Ref:Lu/91/19/PL

Regarding the above application. We wish to object for the following reasons

Sites C & E

SITE LOCATION PLAN AND
BLOCK PLAN - SITE C&D

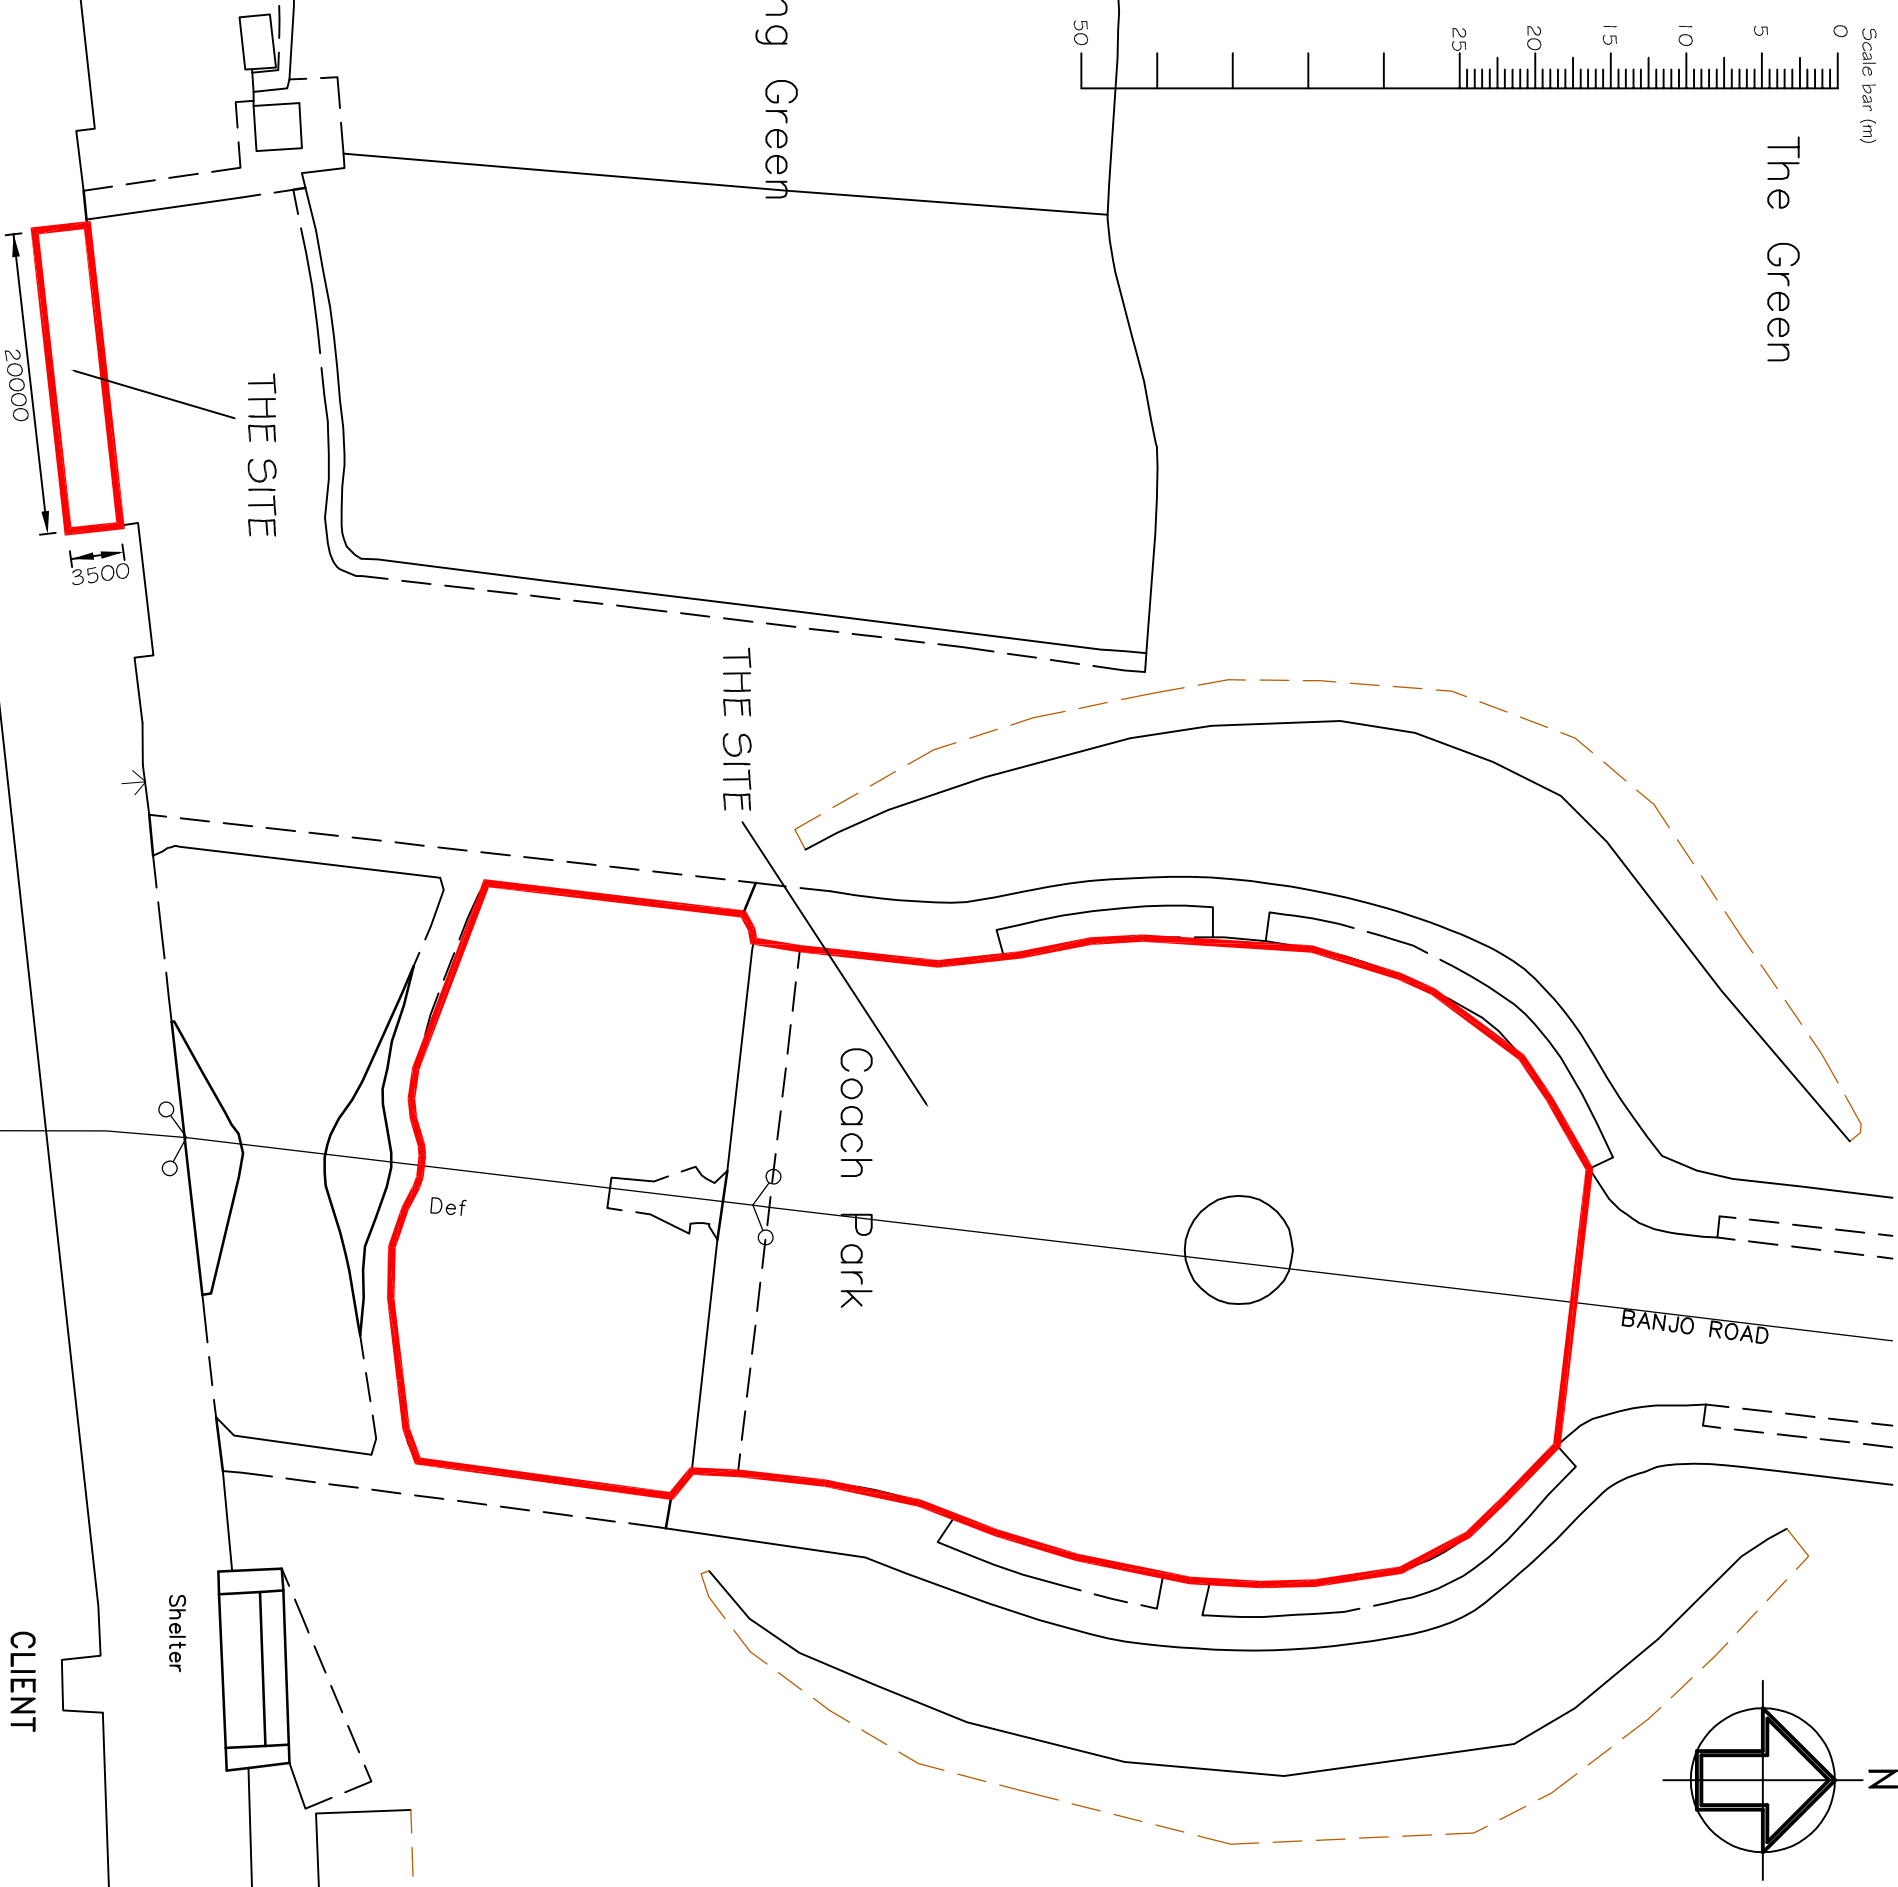
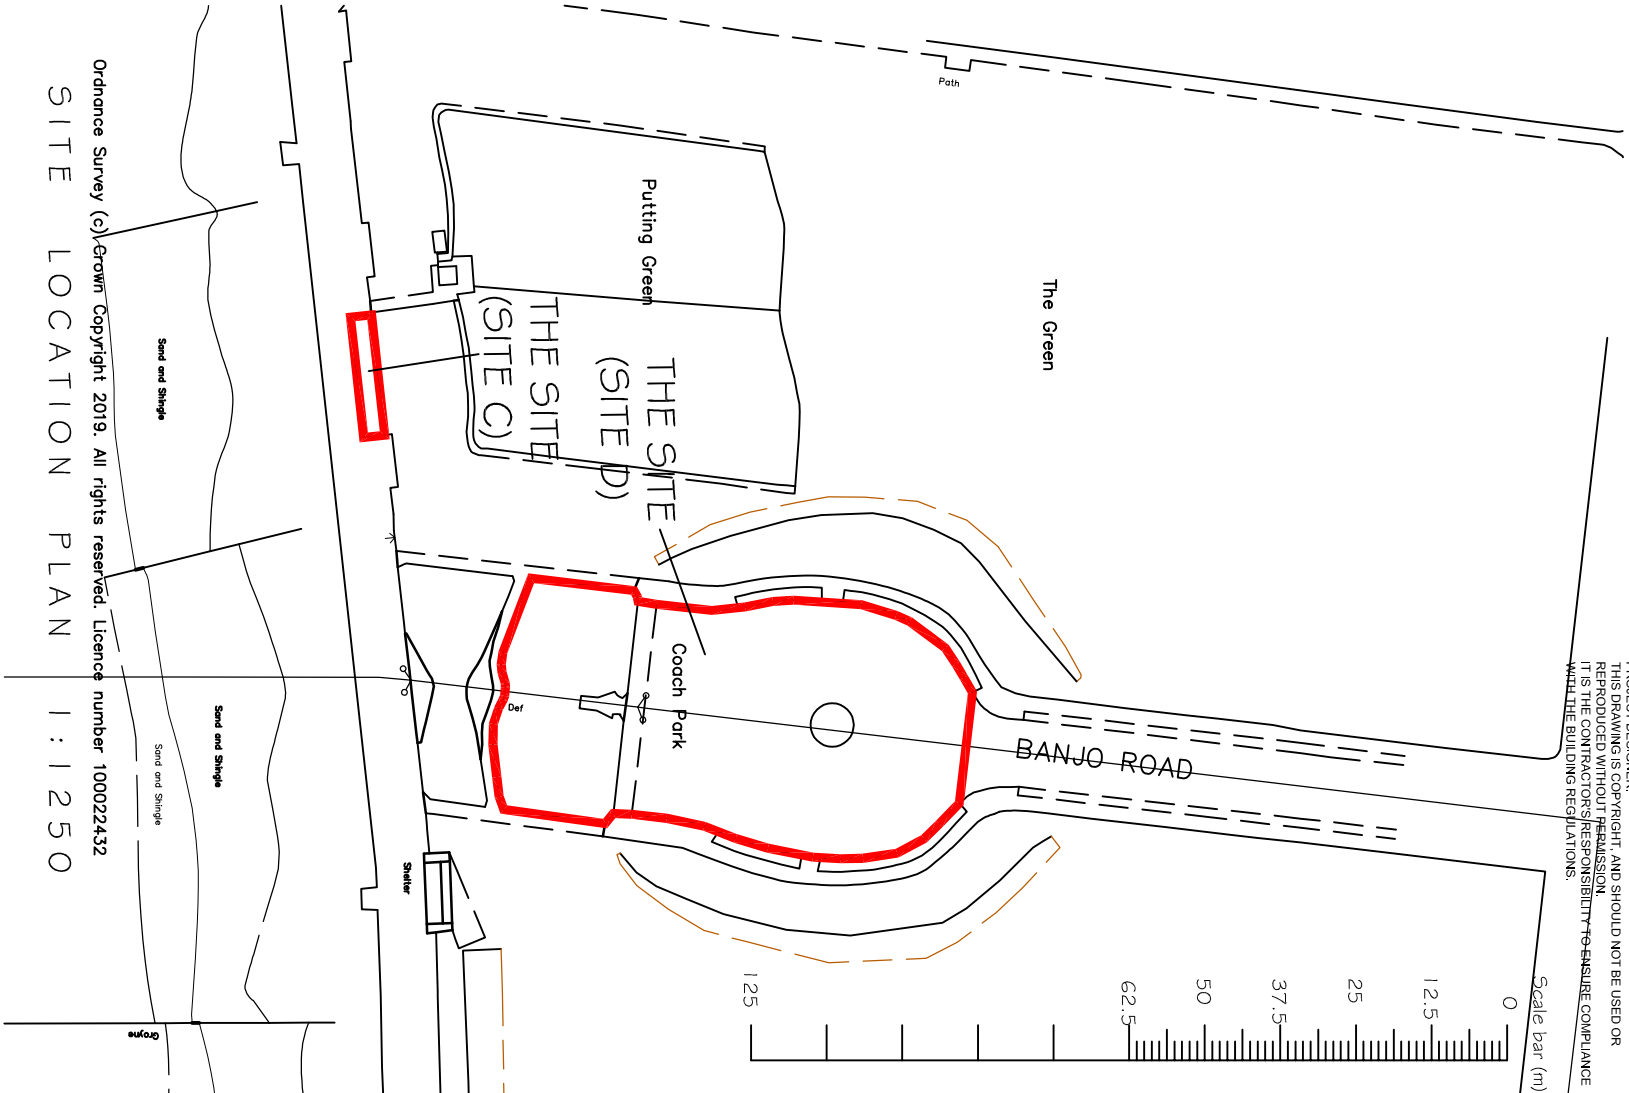
Site D

Loss of coach parking will impact on tourism, Business & block the roads even more around the seafront where they try to park on streets in the area

DRAWING TITLE
SITE LOCATION PLAN AND
BLOCK PLAN - SITE E

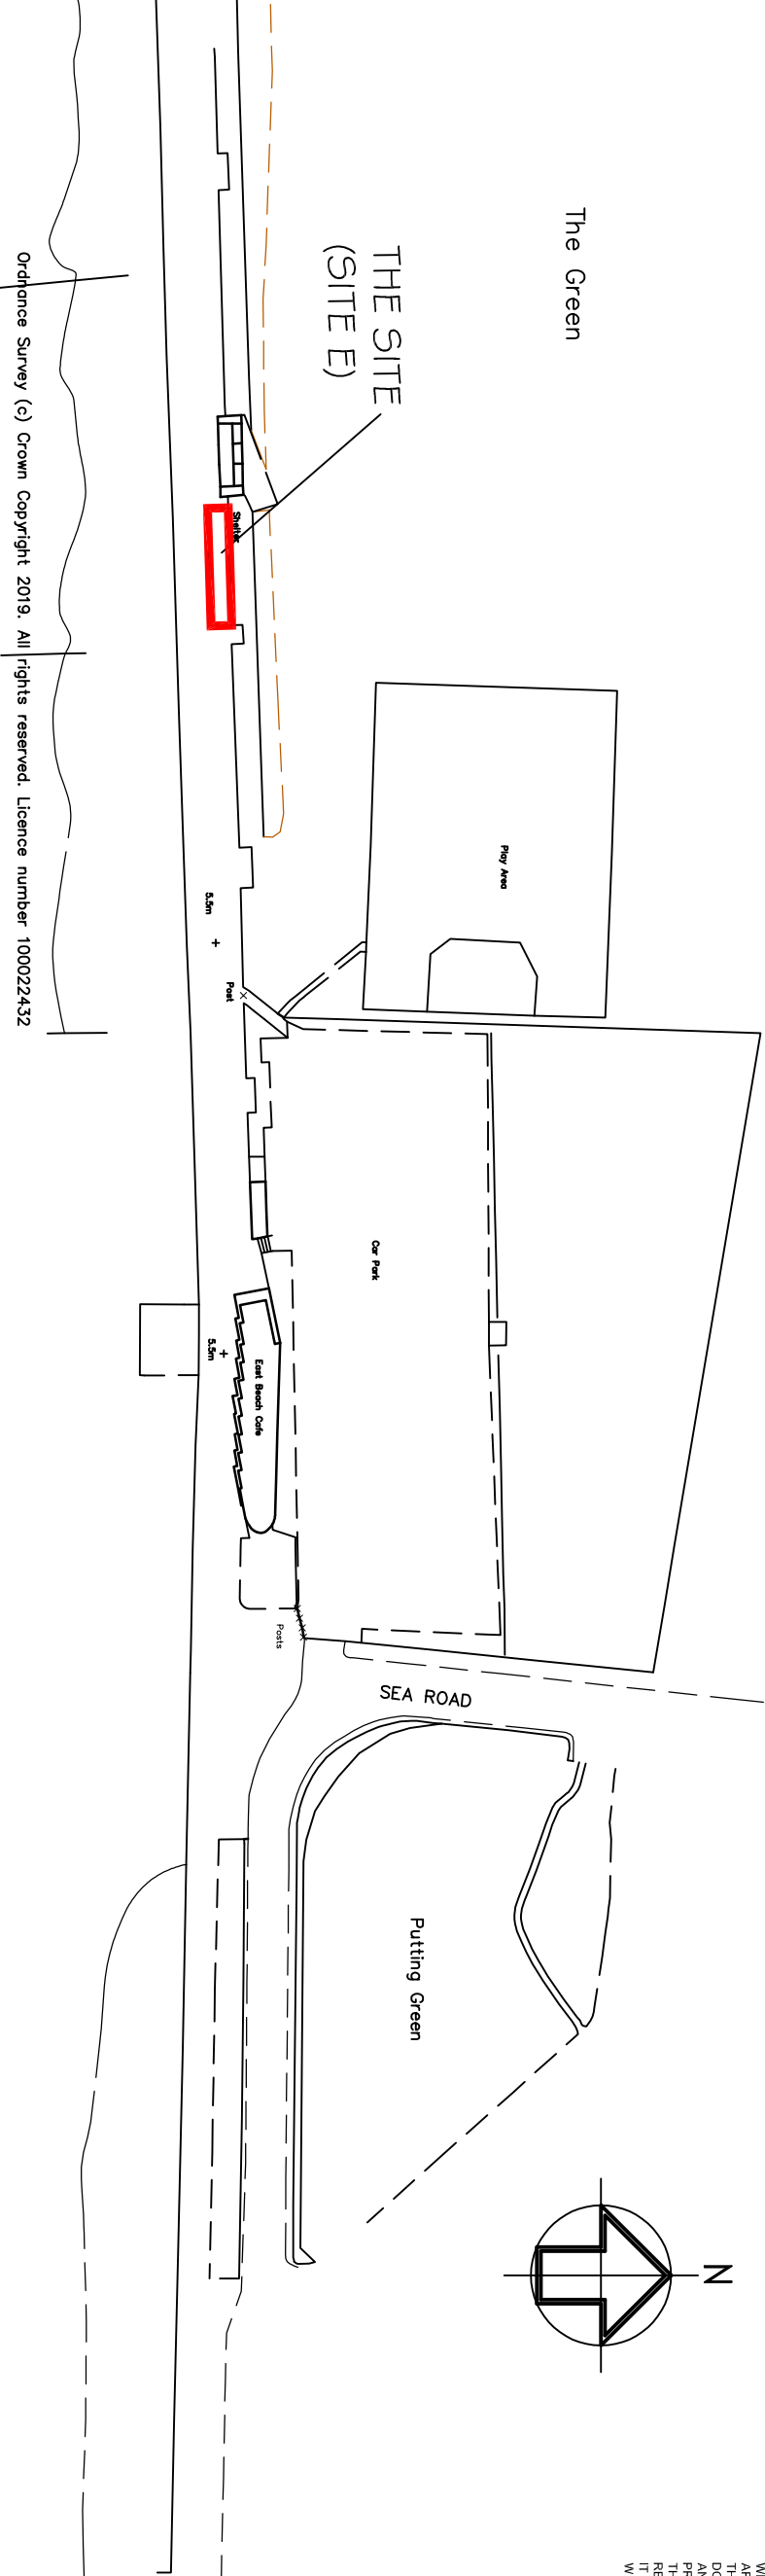
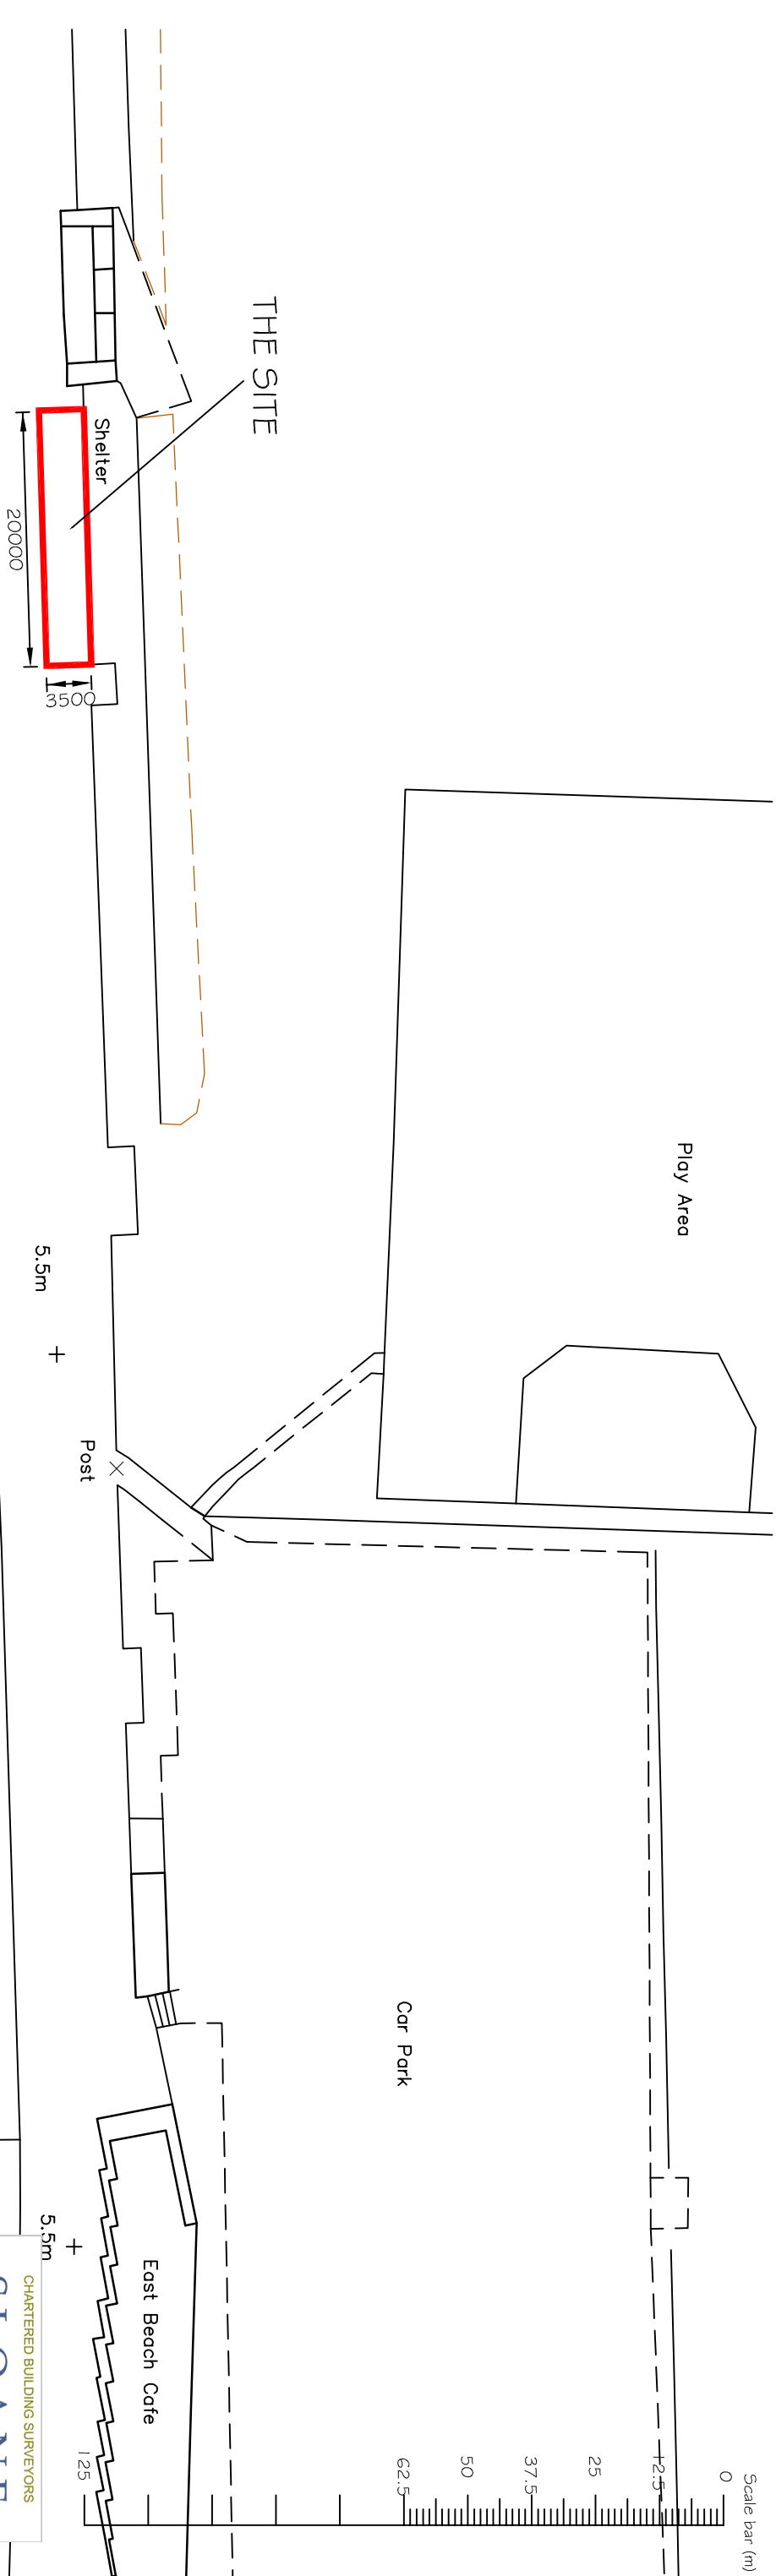
This will create a significant narrowing of the promenade & present a safety risk to the public using the promenade. e.g cycling, pedestrians & the road train. It increases risk of accidents particularly at busy times.

Impacts on the appearance of the open nature of the walkways of the promenade & thereby alters the character of the area.
